## **OXFORDSHIRE COUNTY COUNCIL'S RESPONSE TO CONSULTATION ON THE FOLLOWING DEVELOPMENT PROPOSAL**

**Application no:** 21/04275/OUT

**Proposal:** OUTLINE - with all matters reserved except for Access - Mixed Use Development of up to 3,100 dwellings (including extra care); residential and care accommodation(C2); mixed use local centre (comprising commercial, business and service uses, residential uses, C2 uses, local community uses (F2(a) and F2(b)), hot food takeaways, public house, wine bar); employment area (B2, B8, E(g)); learning and non-residential institutions (Class F1) including primary school (plus land to allow extension of existing Gagle Brook primary school); green Infrastructure including formal (including playing fields) and informal open space, allotments, landscape, biodiversity and amenity space; burial ground; play space (including Neaps/Leaps/MUGA); changing facilities; ground mounted photovoltaic arrays; sustainable drainage systems; movement network comprising new highway, cycle and pedestrian routes and access from highway network; car parking; infrastructure (including utilities); engineering works (including ground modelling); demolition

**Location:** Adj

DRAWING No: 007 **REV:** P3

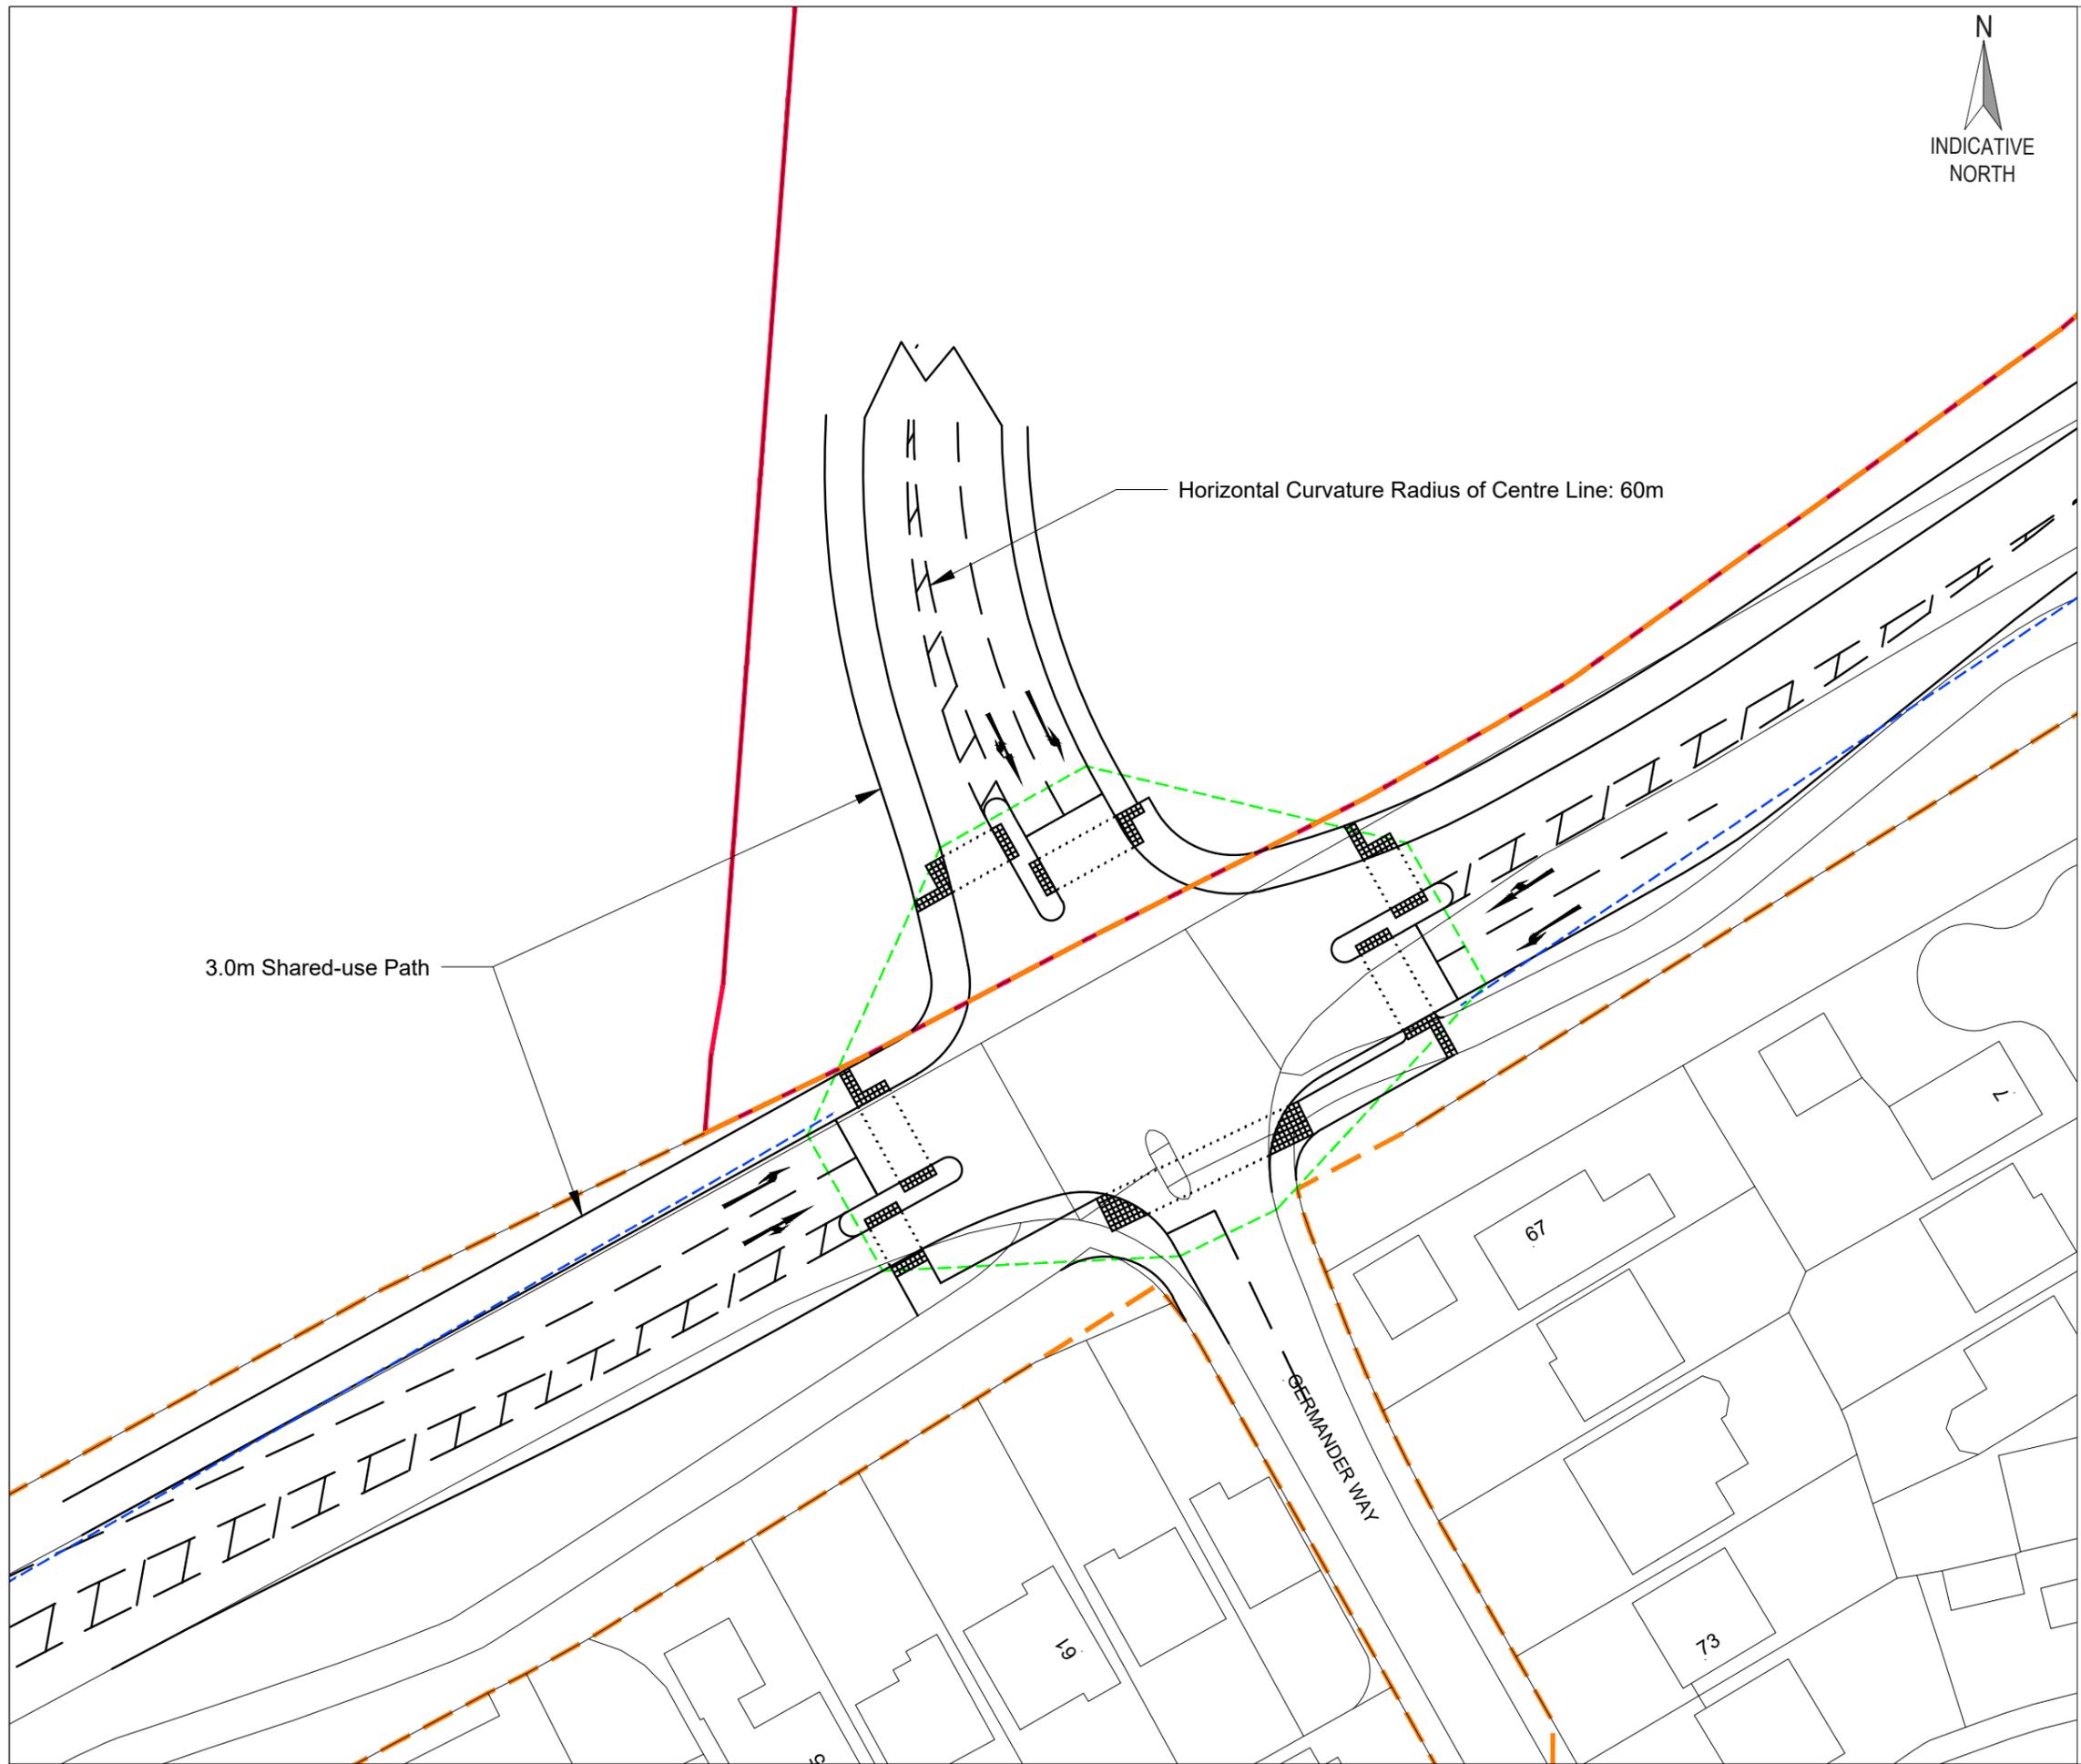
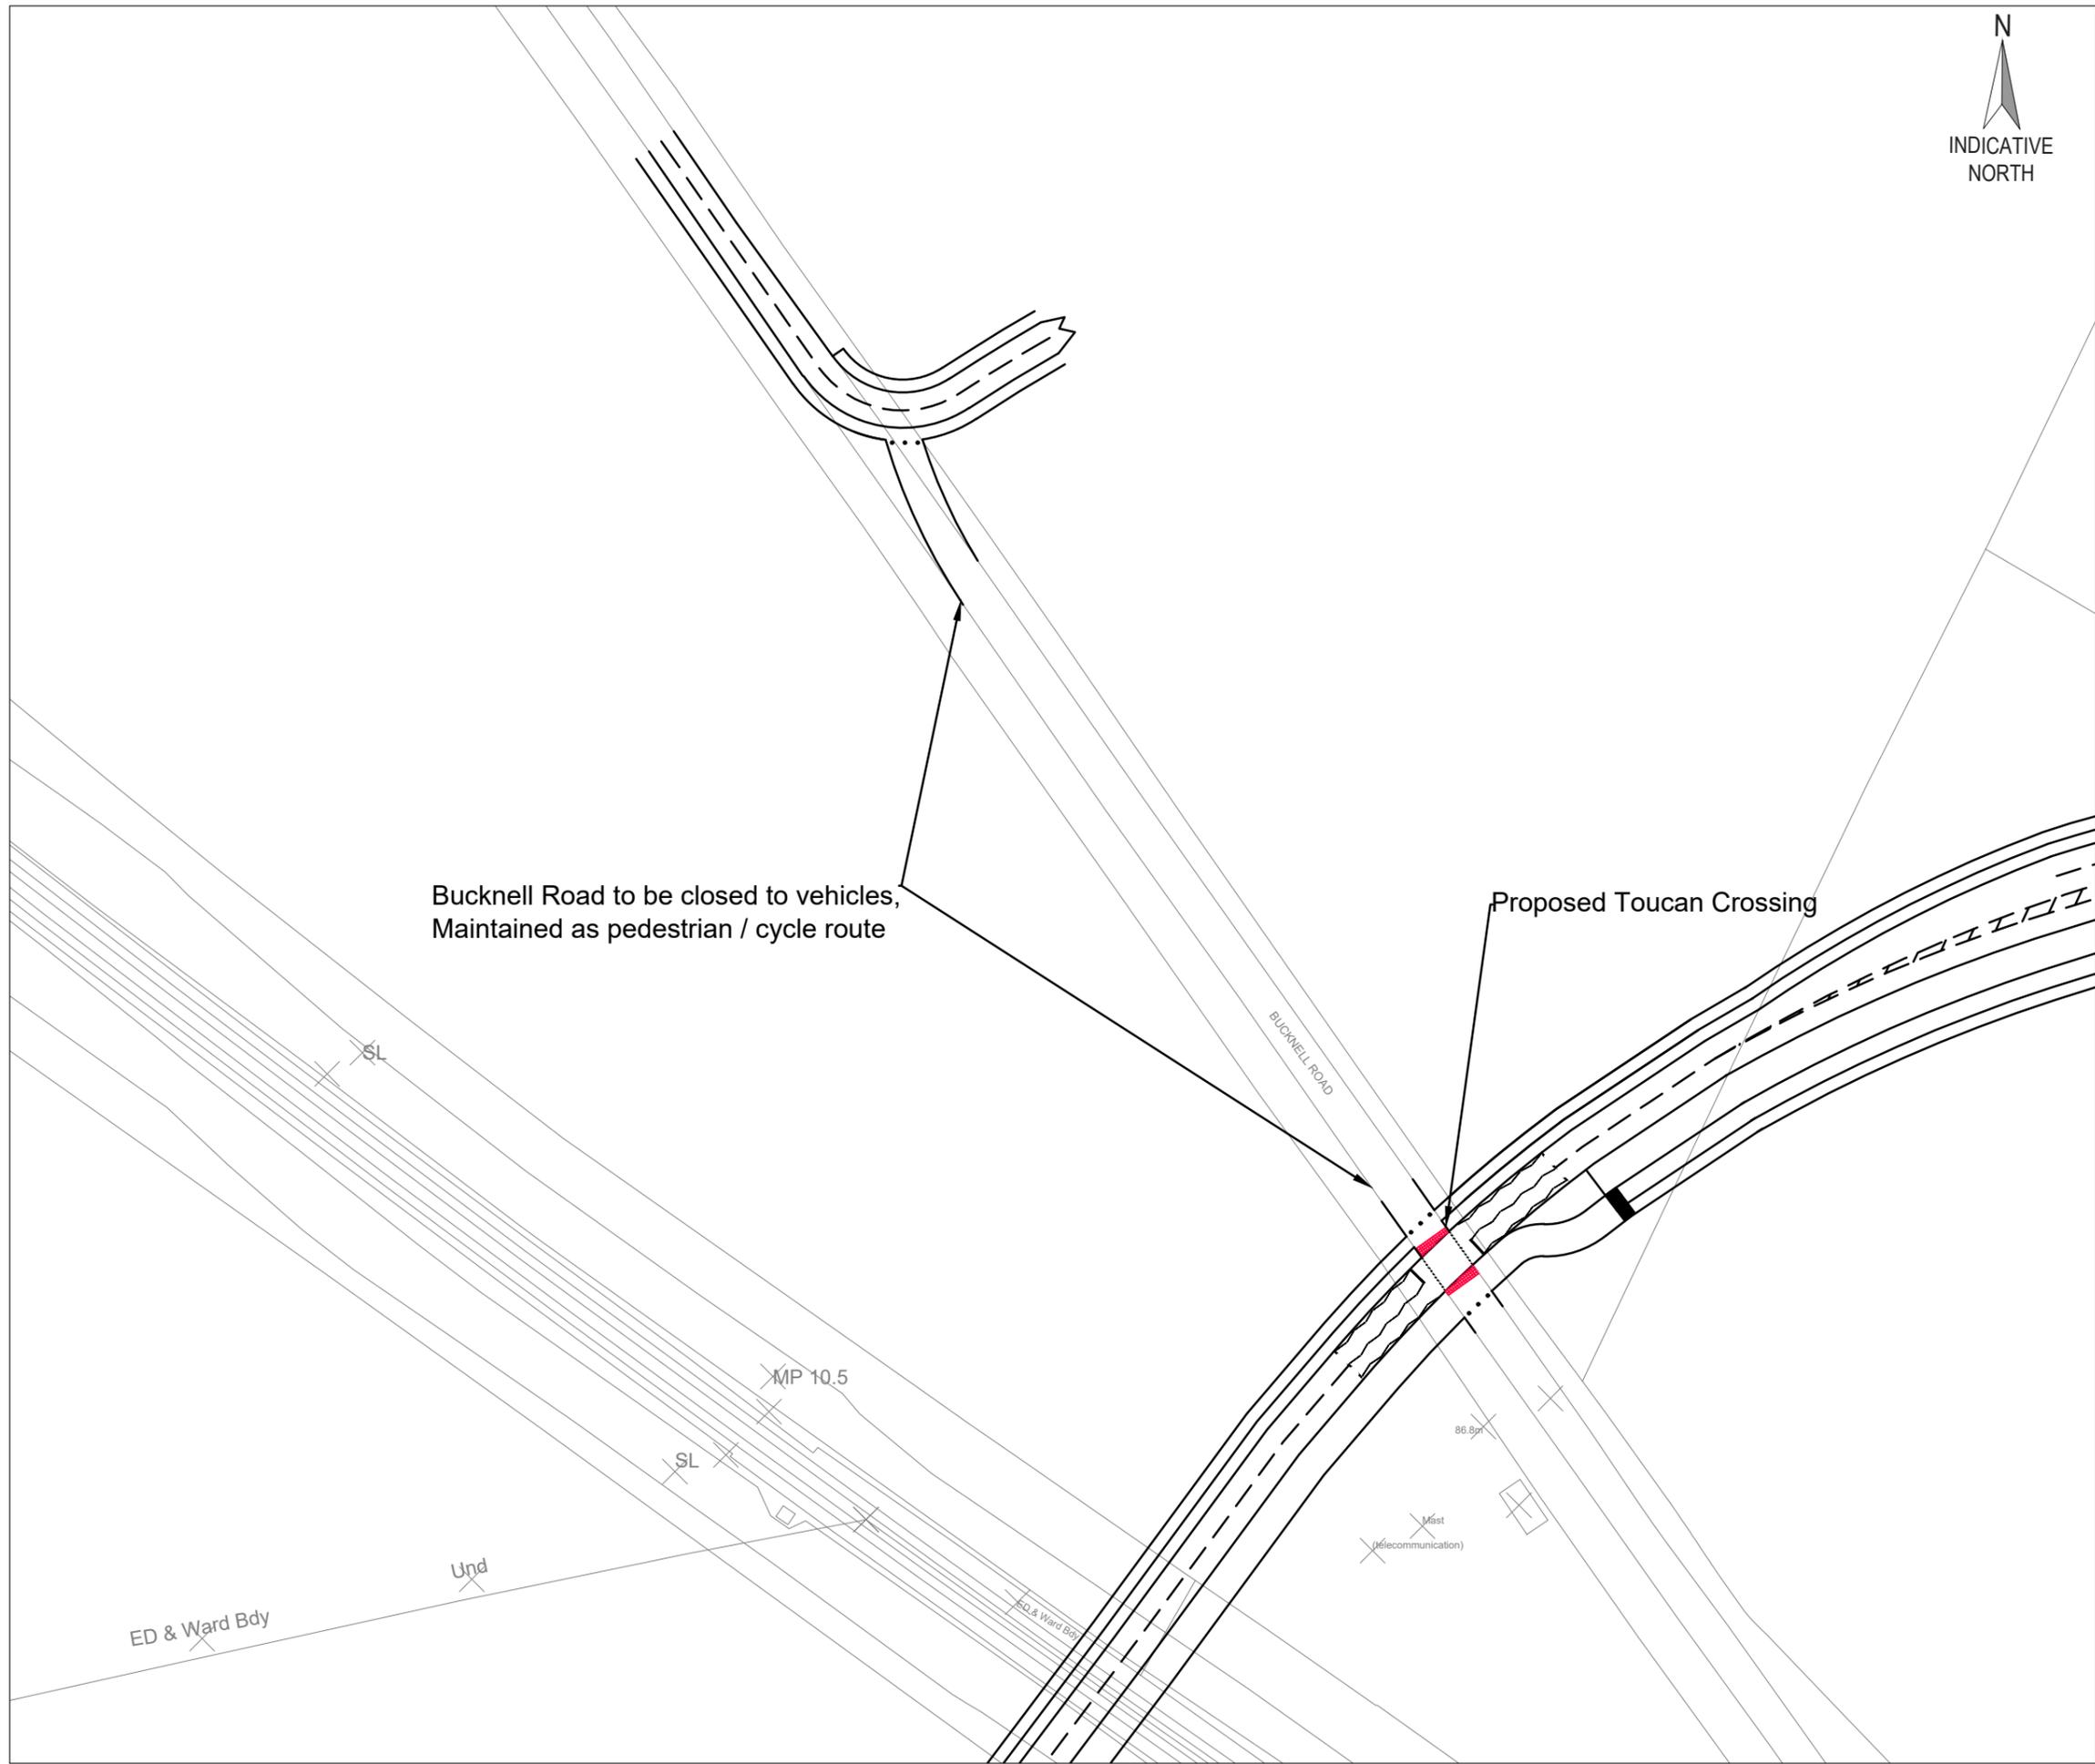
8. Drawings are shown of the main access junctions. These are not approved and will need to be the subject of further discussions with OCC including the traffic signals team. The junctions will also need to be modelled for traffic capacity. Crossings should be straight across rather than staggered, and segregated cycle facilities will need to be provided on both sides of all arms. A simultaneous green ped/cycle phase design should be considered.
